CITY OF ALBUQUERQUE

**RE: Broadstone Highlands North Block
Grading and Drainage Plan
Engineer's Stamp Date: 10/12/17
Hydrology File: K15D034A**

DRAINAGE MANAGEMENT PLAN

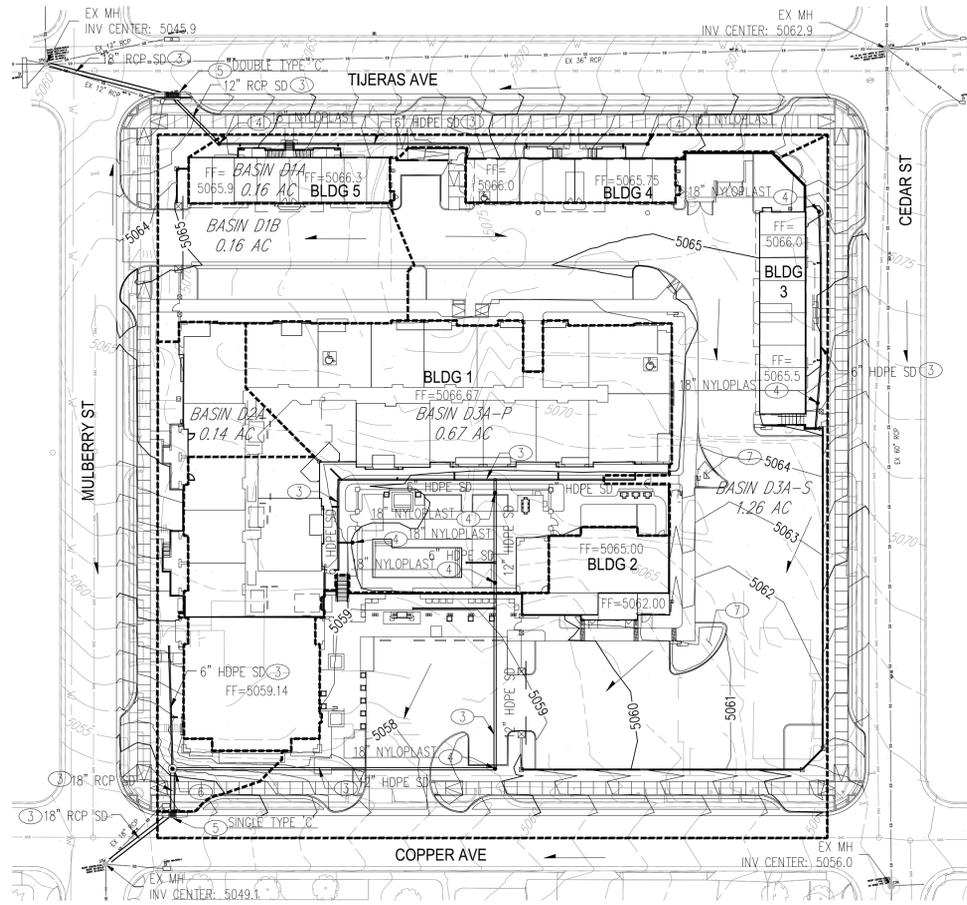
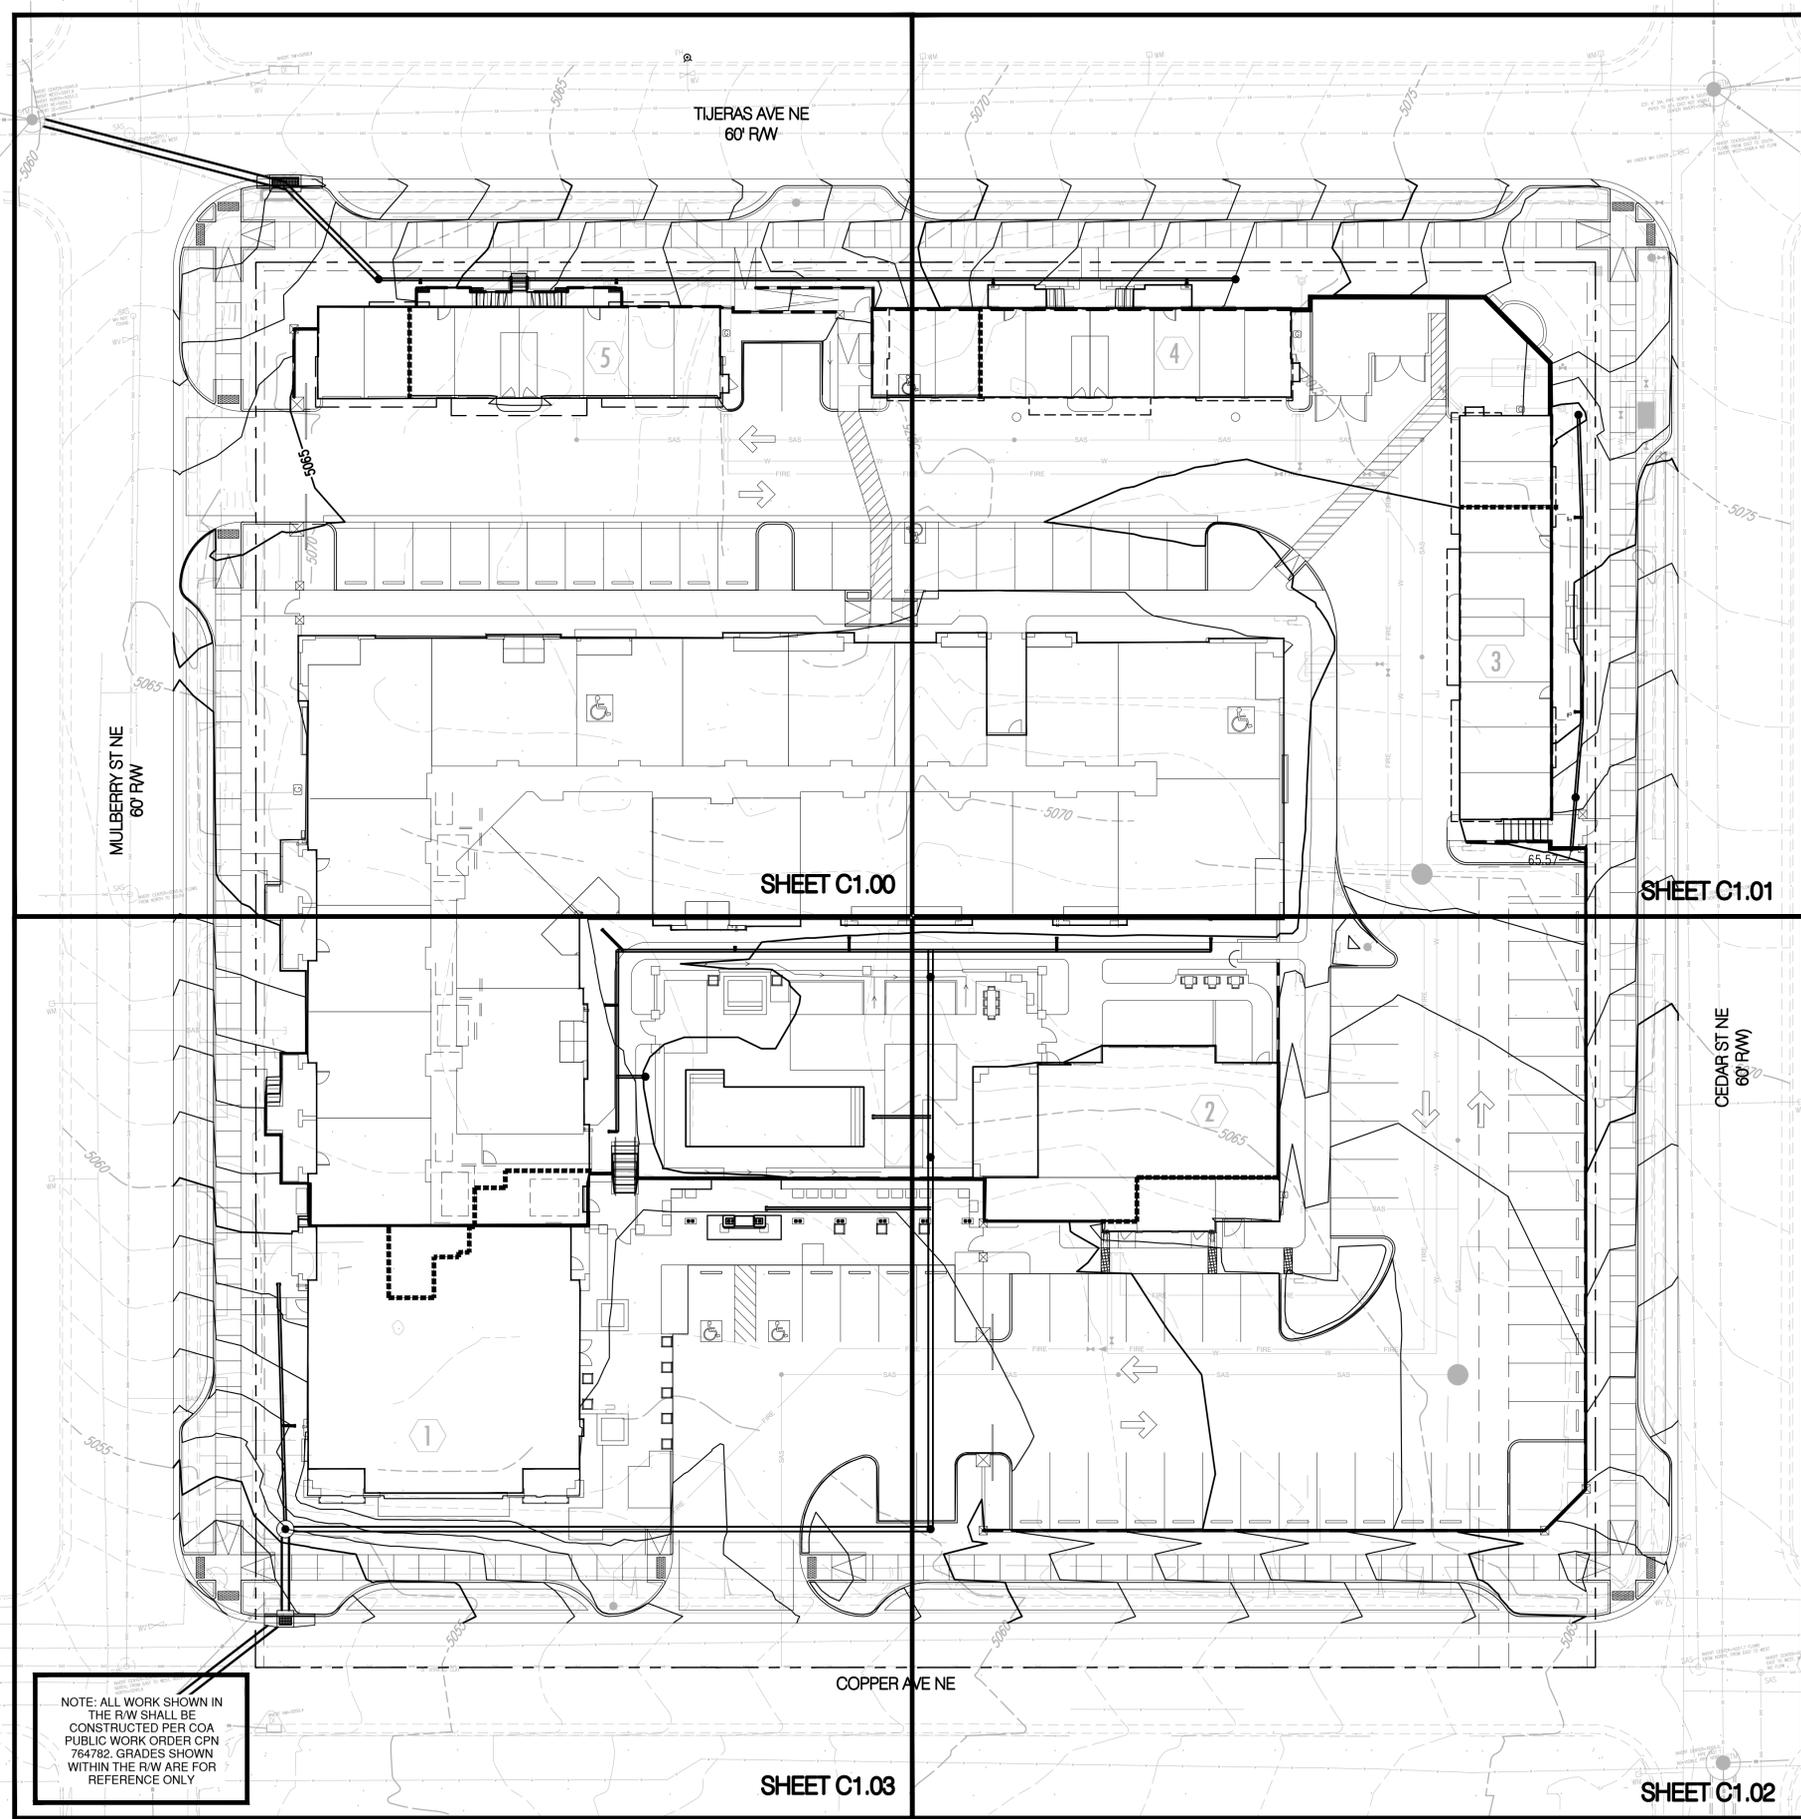
1. This project requires an ESC Plan, submitted to the Stormwater Quality Engineer (Curtis Cherne PE, ccherne@cabq.gov).
2. A revocable permit for the footer encroachment into the Cedar St public ROW is required.
3. Construction plans for work in the public ROW need be to be submitted to DRC for review.
4. Payment of the Fee in Lieu (Amount = $2,664\text{CF} \times \$8/\text{CF}$, per sheet C0.01) for the required first flush volume must be made.
